From: Laura Gibbons <Laura.Gibbons@arun.gov.uk>
Sent: 05 January 2021 14:55
To: Planning.Responses <Planning.Responses@arun.gov.uk>
Cc: Simon Davis <Simon.Davis@arun.gov.uk>
Subject: RE: Planning Consultation on: Y/147/20/DOC

We have the following comments regarding the application to discharge condition 5:

Description of Works: Approval of details reserved by condition imposed under ref APP/C3810/V/16/3158261 (Y/19/16/OUT) relating to Condition Nos 5 - surface water drainage and 6 - foul drainage system

Drawing Title
**SURFACE WATER PUMPING STATION
OVERFLOW LONGSECTION**

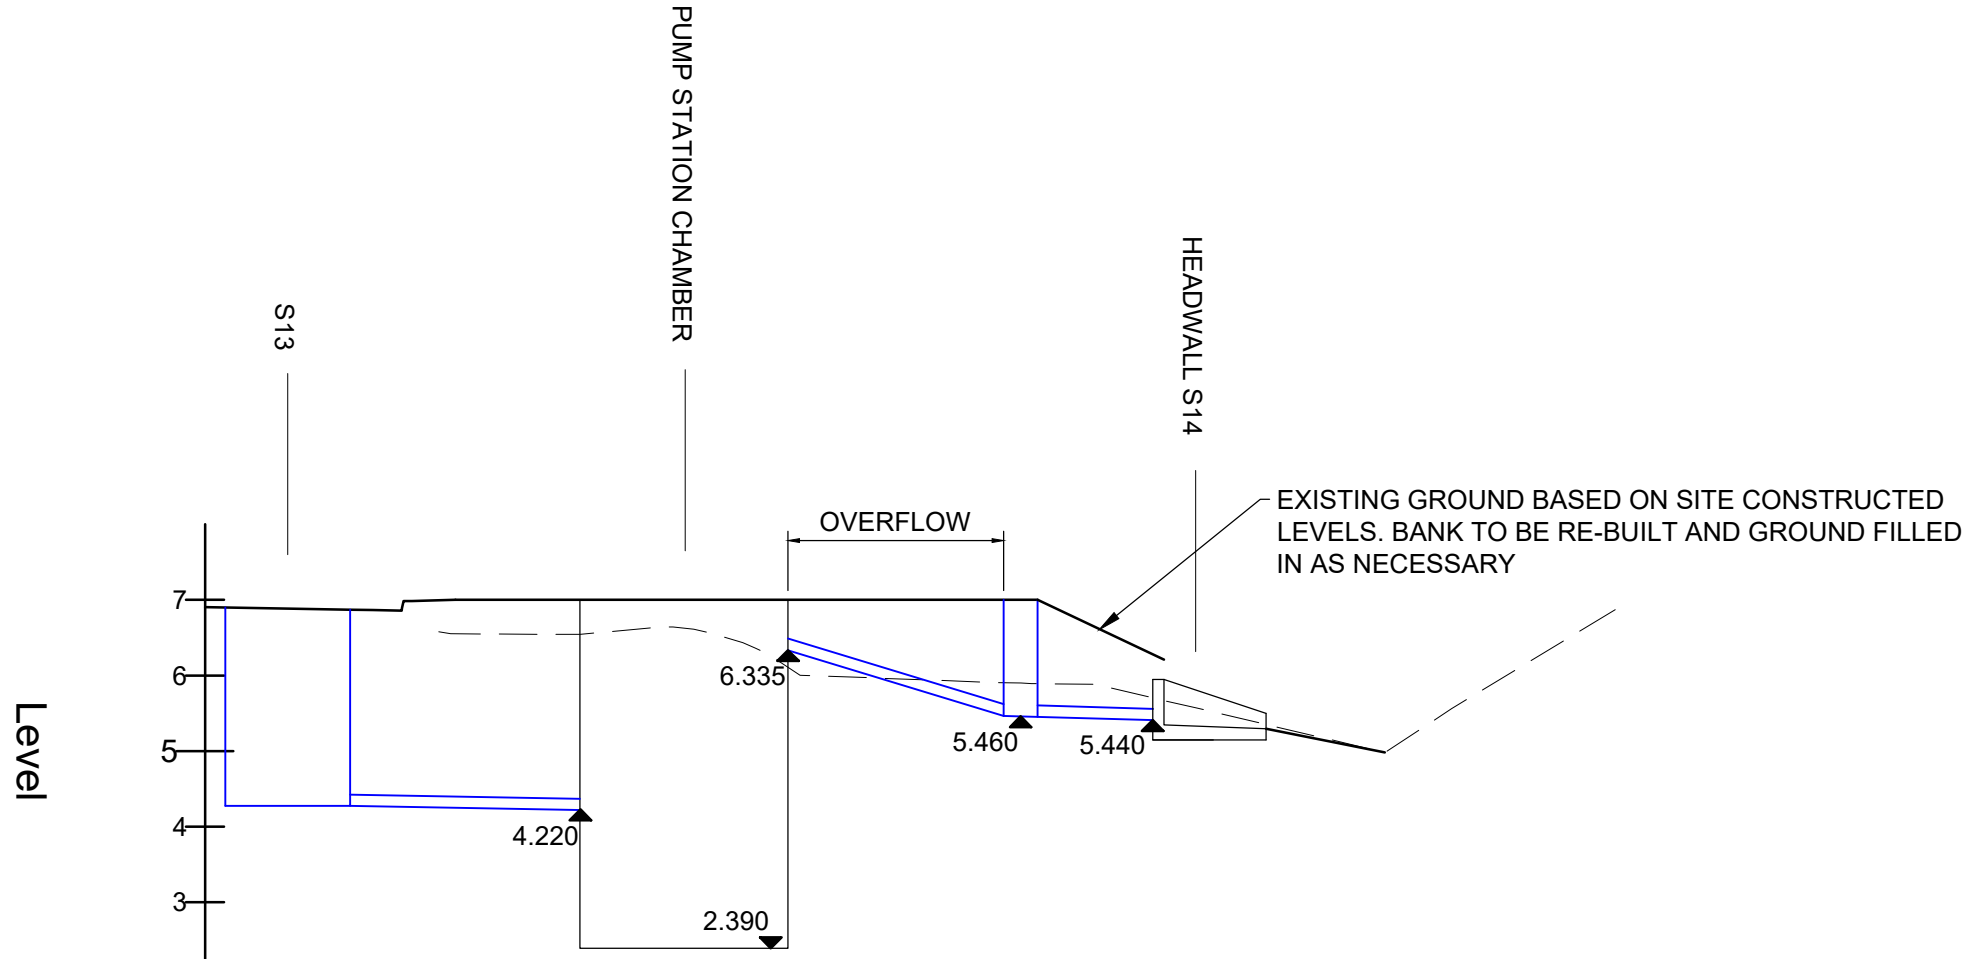
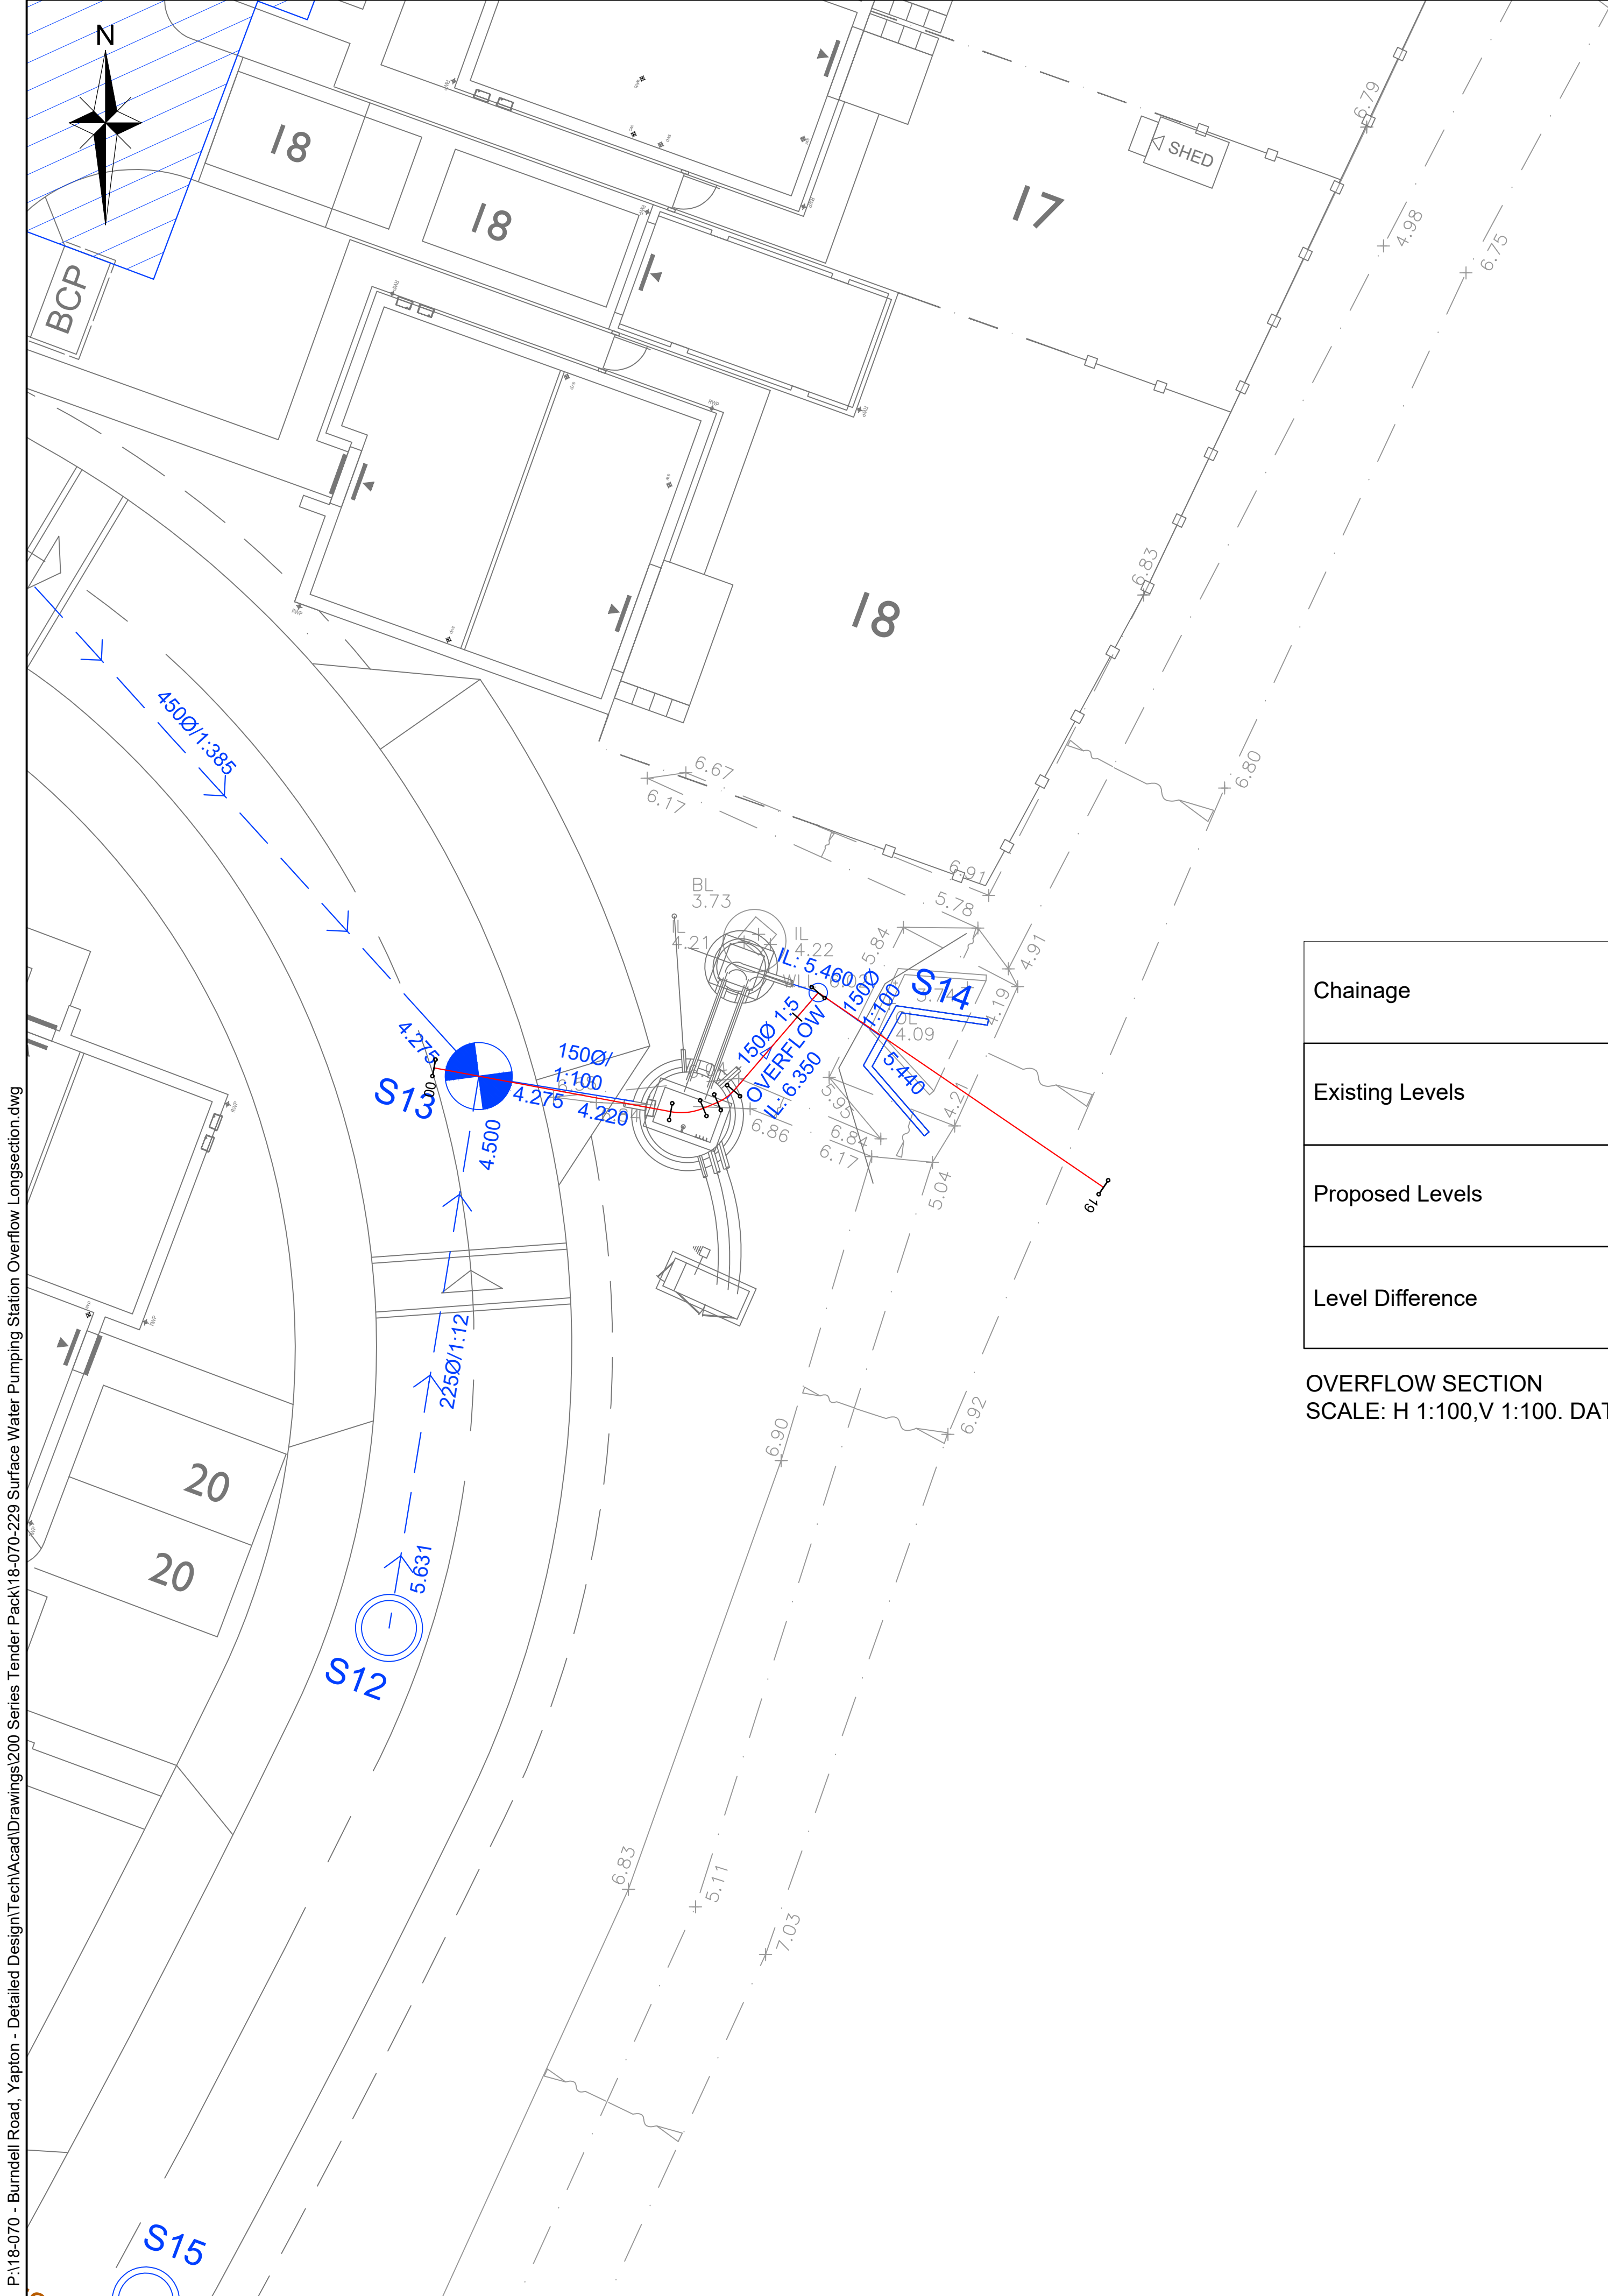
It is understood that an error in the original survey has resulted in the northern drainage catchment being constructed too deep and that a pumping station is now proposed to discharge water to the ditch. We do not support this proposal for the following reasons:

- a) It is standard practice for drainage to be constructed from the downstream up. If this had been completed the problem would not have occurred as the levels discrepancy would have been picked up from the start and adjustments made.
- b) Pumping stations are prone to failure and we are aware of sites in the county where pumping stations have resulted in on and offsite flood risk being increased.
- c) Pumping stations are not sustainable.
- d) Pumping stations require significant maintenance, this will place an unreasonable financial burden upon residents.

- e) Insufficient justification has been provided to demonstrate that a gravity solution cannot be achieved. If it is required to reconstruct some of the drainage network then this should occur.
